Recommendation Report for Approval of Reserved Matters Following Outline Approval

REF NO: BN/28/17/RES

LOCATION: Land R/O Lillies
Yapton Road
Barnham
PO22 0AY

PROPOSAL: Approval of reserved matters following outline consent BN/32/15/OUT relating to appearance, landscaping, layout & scale for erection of 38 No. dwellings including open space, landscaping & new access

scheme: The Lillies, Yapton Rd
Barnham
client: Matthew Homes
drawing: Landscape Proposals
date: April 2017
scale: 1:200@A1
drawing no: MAT21212 11A sheet 1
drawn: AE checked: DKM

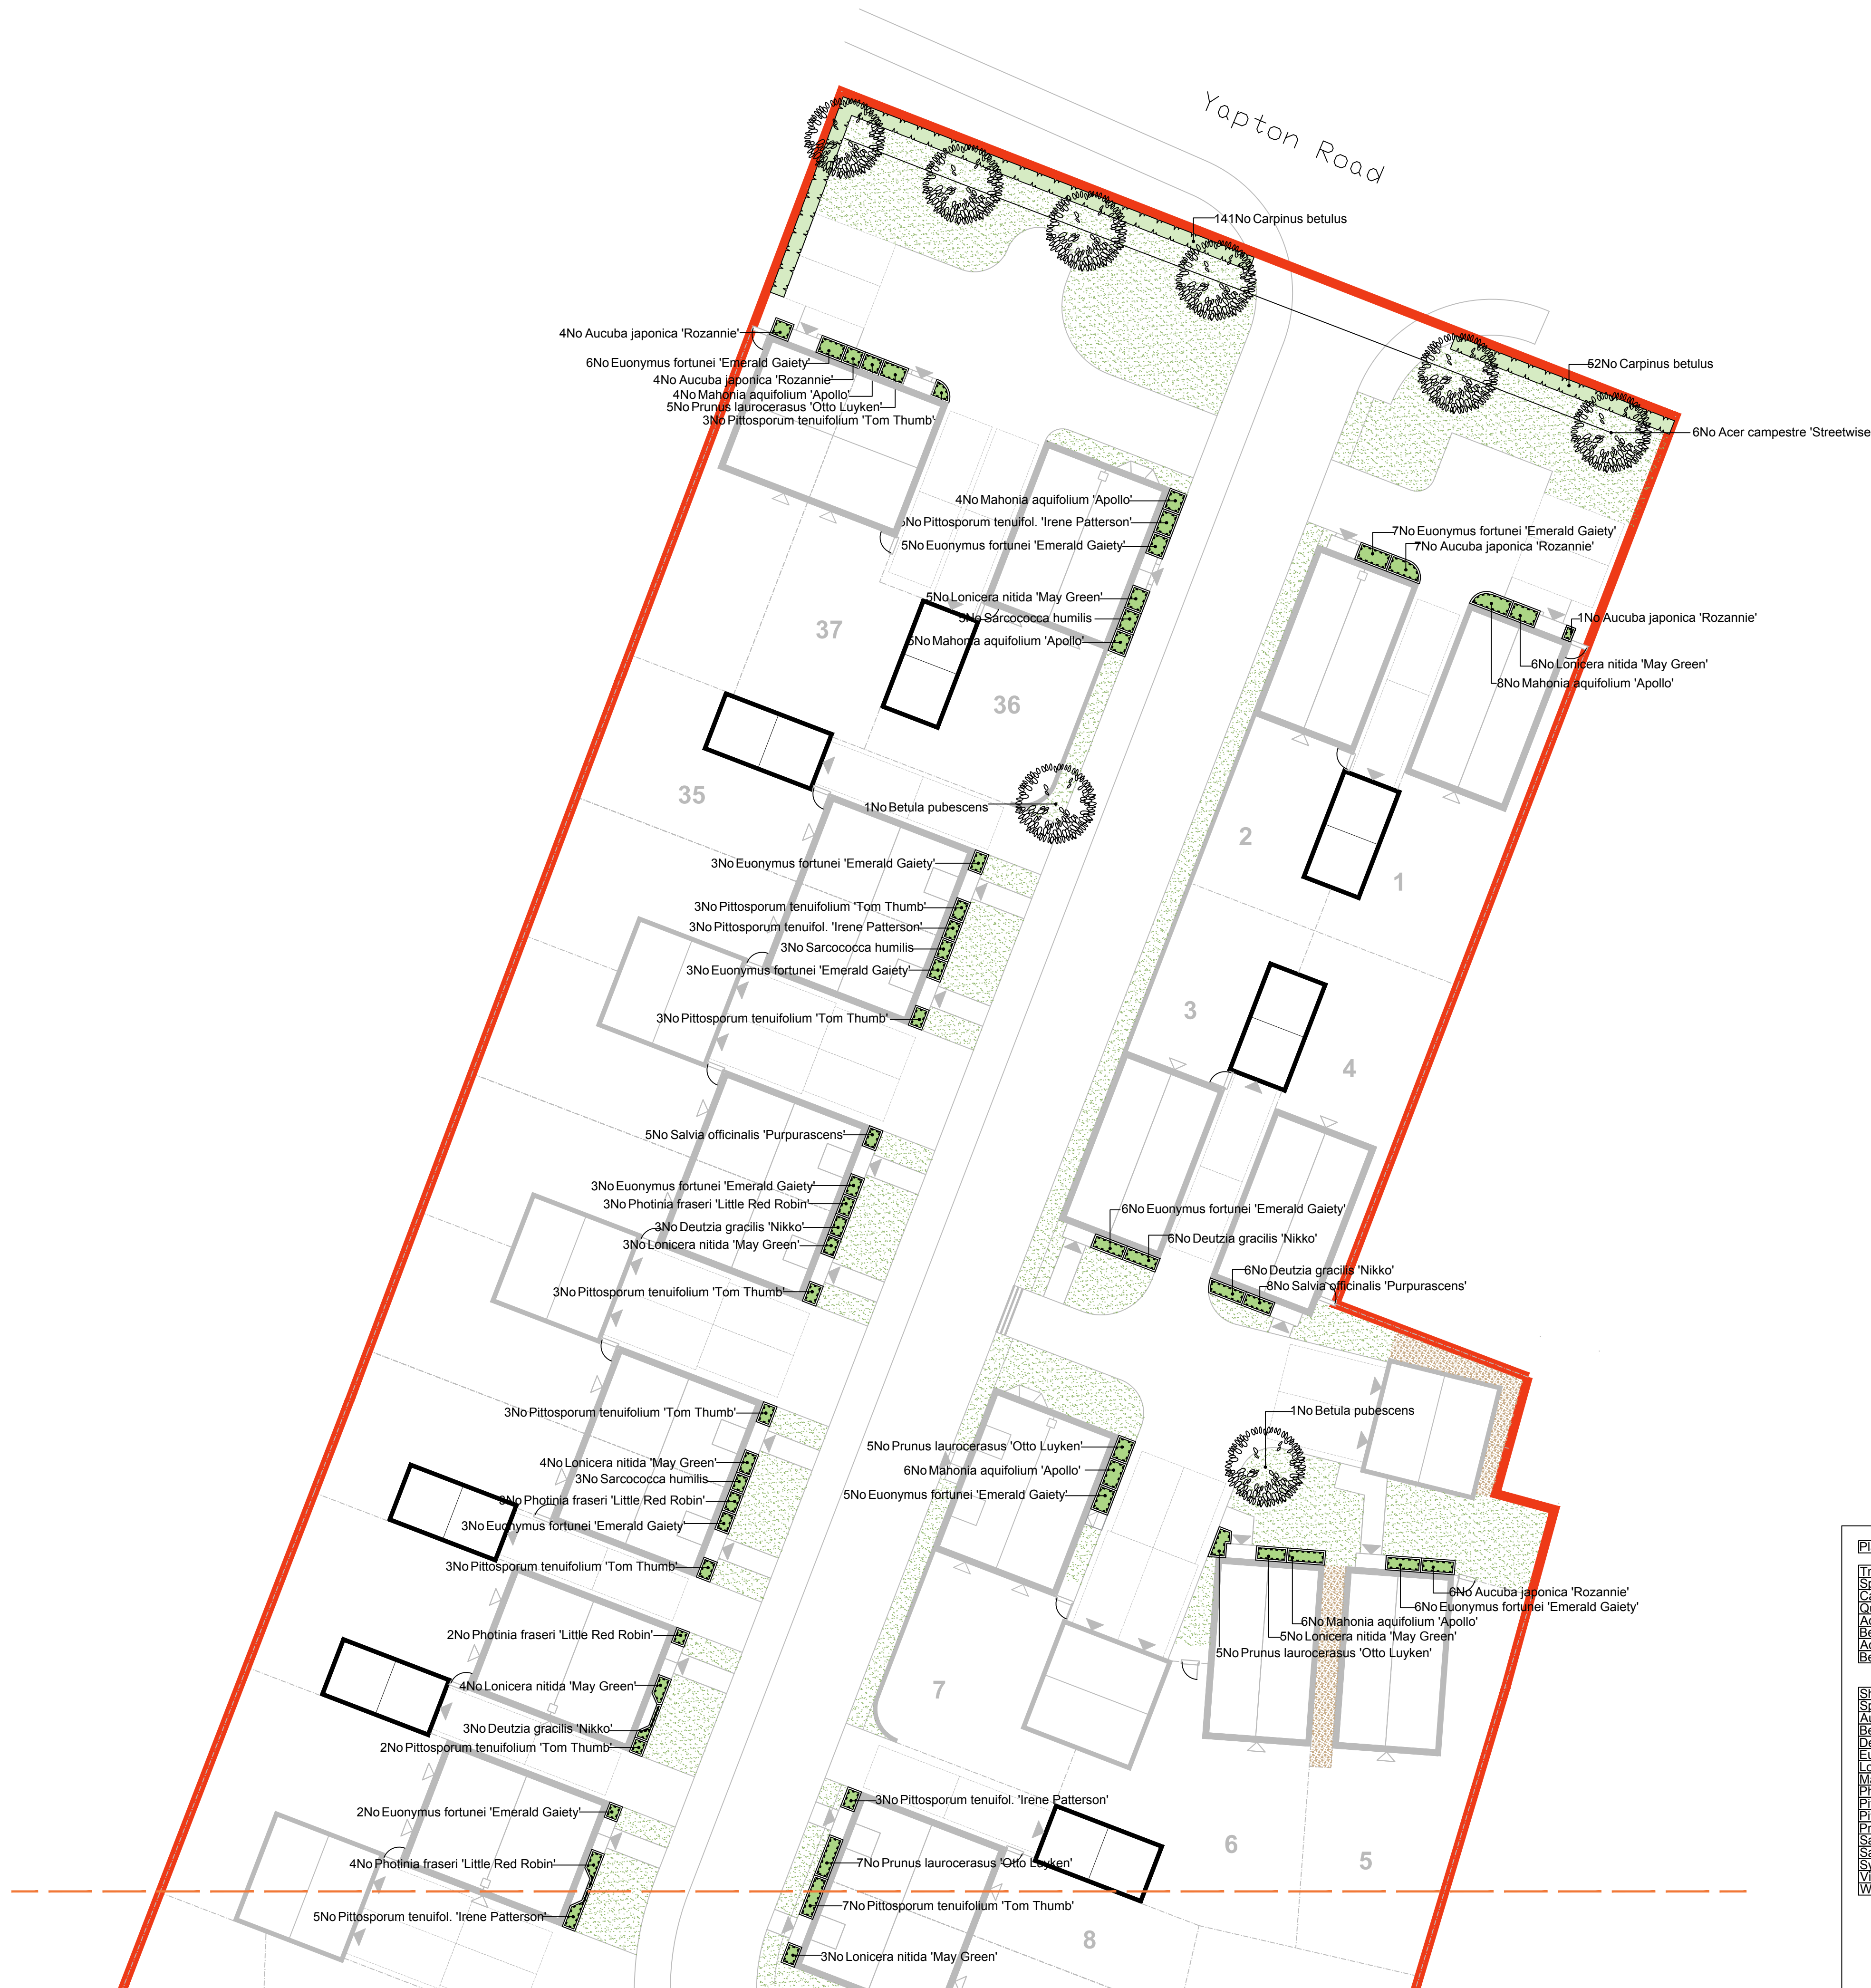
Hedgerow planting is proposed along the frontage with Yapton Road, along the site entrance and in front of all of the properties on the site. However, the area of landscaping along Yapton Road is now shown as significantly reduced in area with a hardstanding and vehicular turning area, compared with the layout submitted at the outline planning stage (BN/32/15/OUT). The landscape scheme includes isolated tree planting along the estate road; and along the western boundary of the public open space; but it could be enhanced by an avenue of trees on both sides of the carriageway which runs from north to south through the application site.

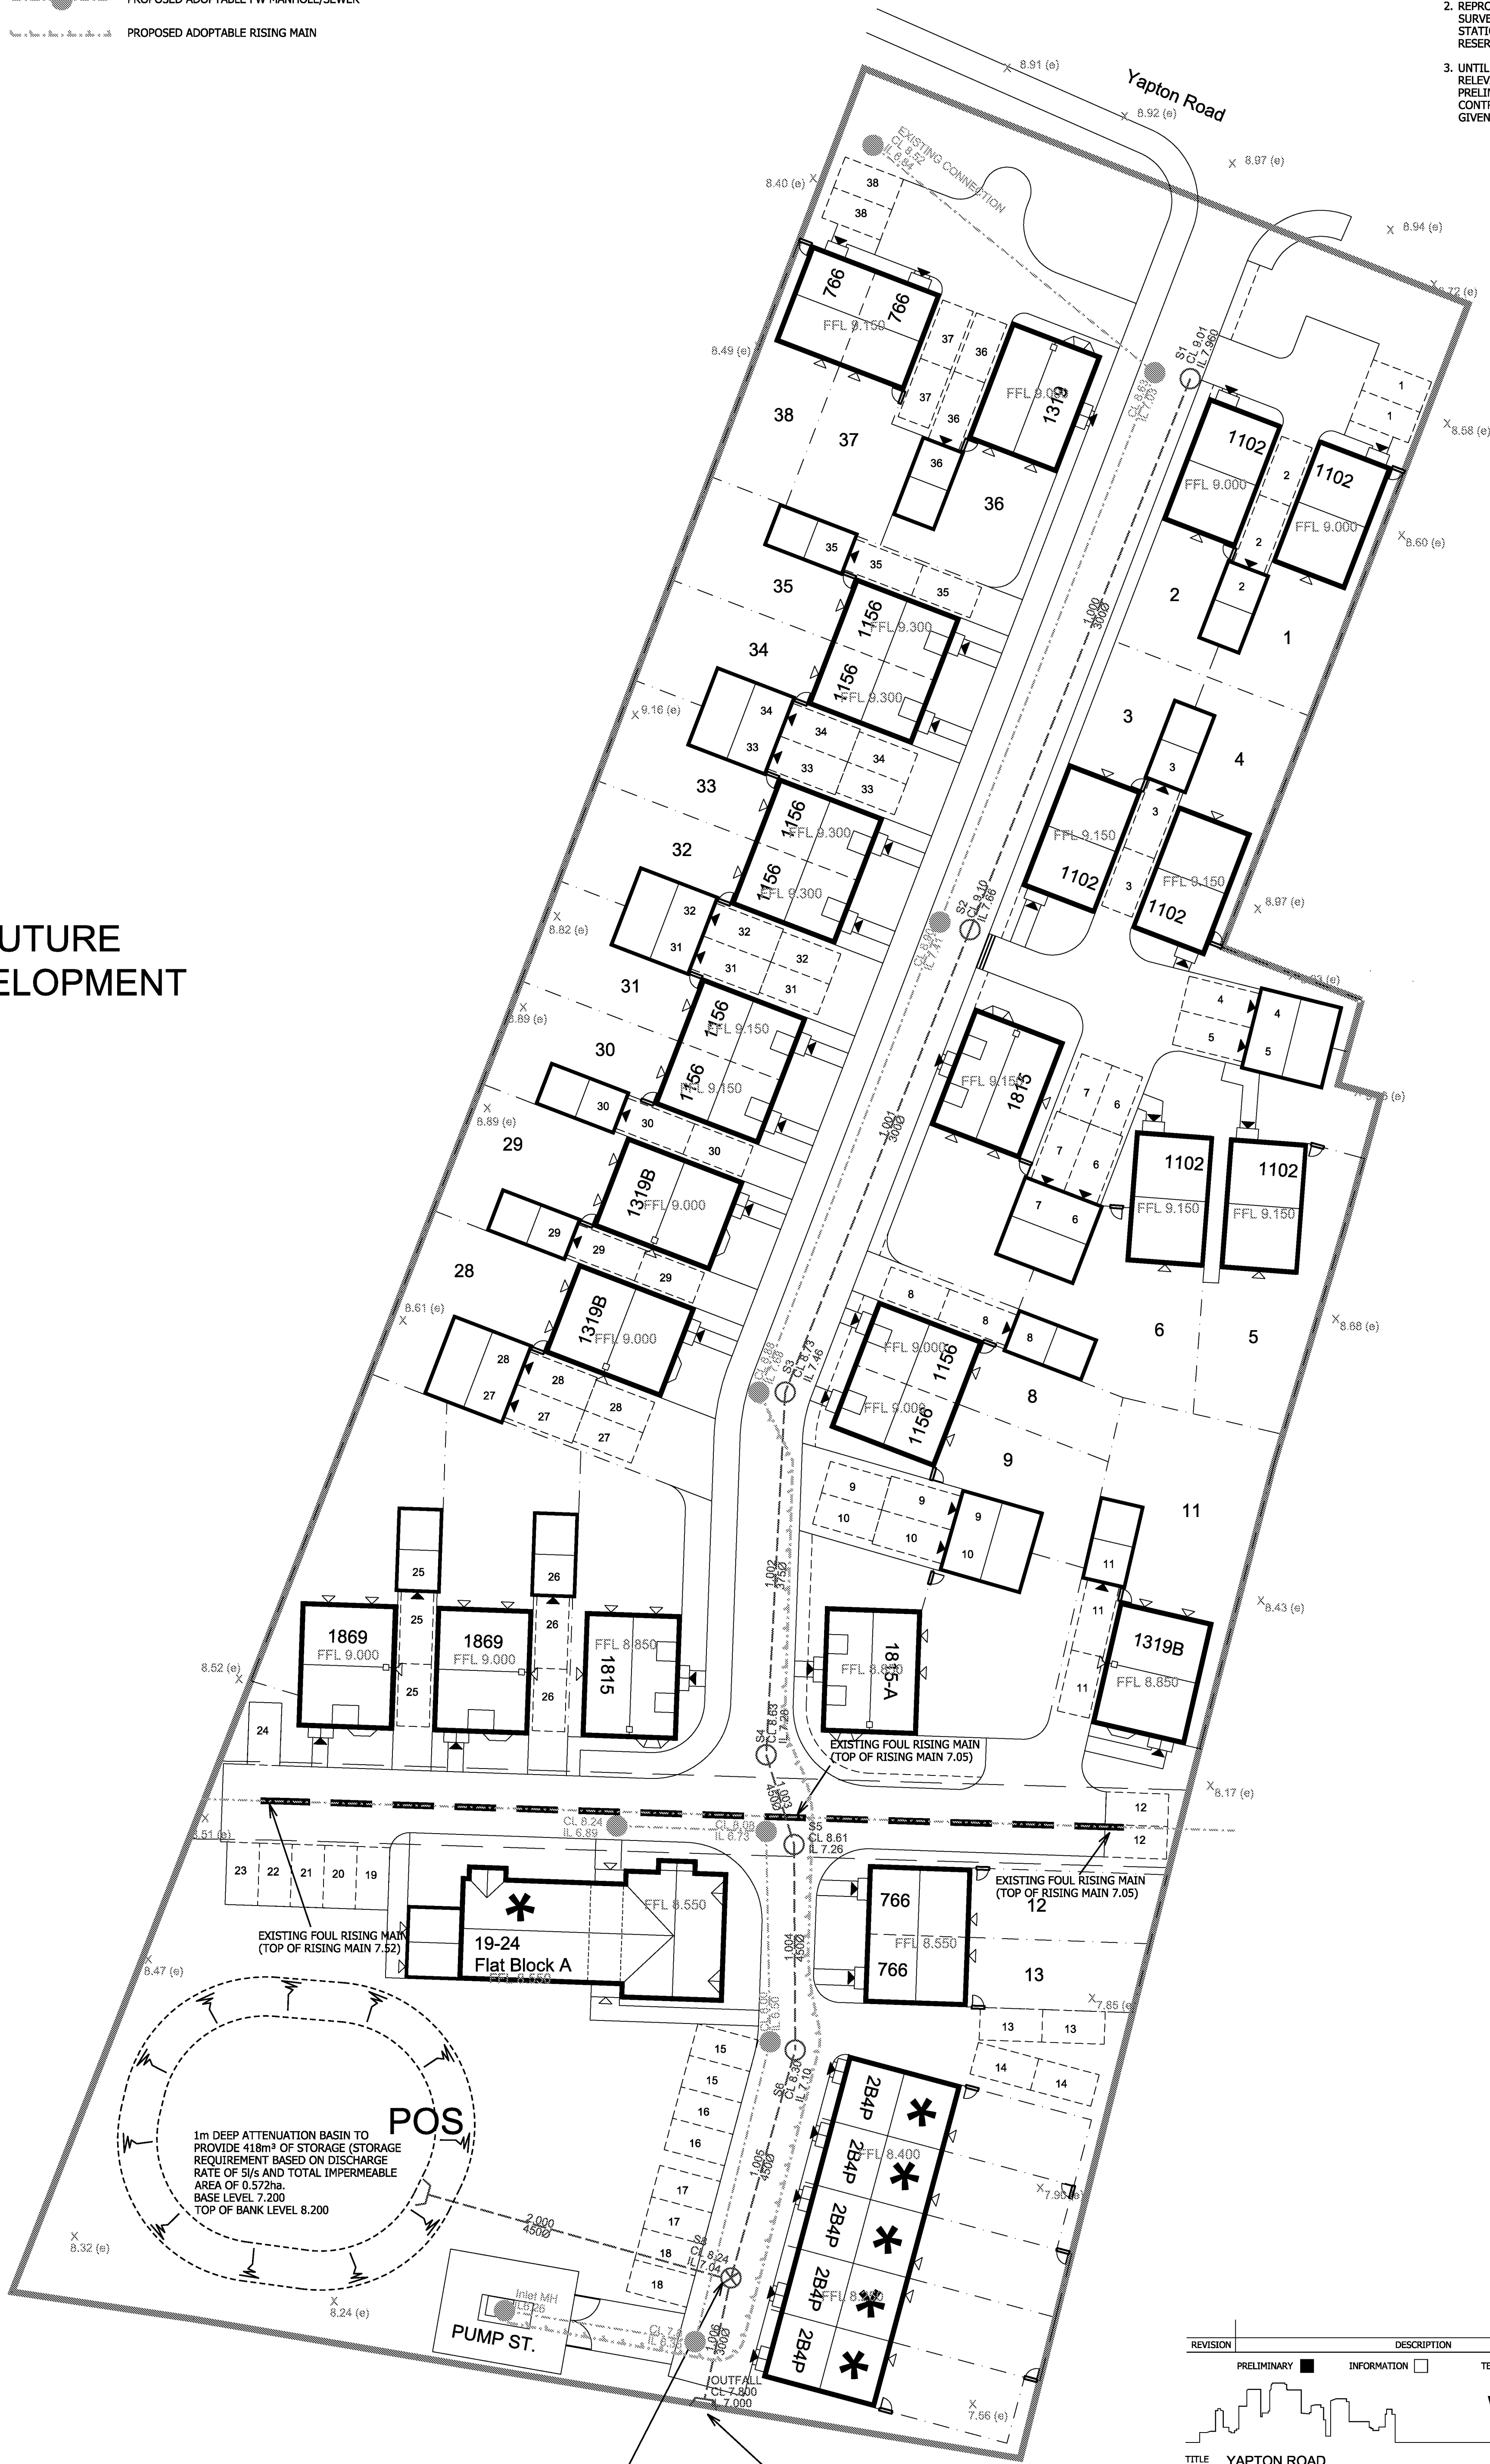
The submitted Drainage Strategy drawing is purely a 'strategy' showing the bare minimum of details. It is not a detailed design. The detailed design will need to include the following:

- A. A fully detailed drainage layout incorporating road/driveway/roof drainage elements;
- B. Hydraulic calculations to support the proposals;
- C. Fully detailed construction details of all drainage elements, including the pond; and
- D. It is understood that the applicant has cleaned out the ditch adjacent to the site boundary, however, it is evident that the section of ditch immediately downstream is heavily vegetated/silted and will impact on the proposed residential development. The applicant needs to advise of their intentions in this respect, bearing in mind the ditch downstream is on third party land. ADC Drainage Engineers hope that the applicant can come to a mutual agreement with the third party landowners, as it is in their interest.

The detailed drainage design will need to be dealt with under a DOC application. However, the proposed drainage drawing provided to date has been lacking in terms of SuDS features to provide adequate water treatment. ADC Drainage Engineers made comments on the outline planning application (BN/32/15/OUT) mentioning the use of permeable surface driveways. Whilst infiltration has now been
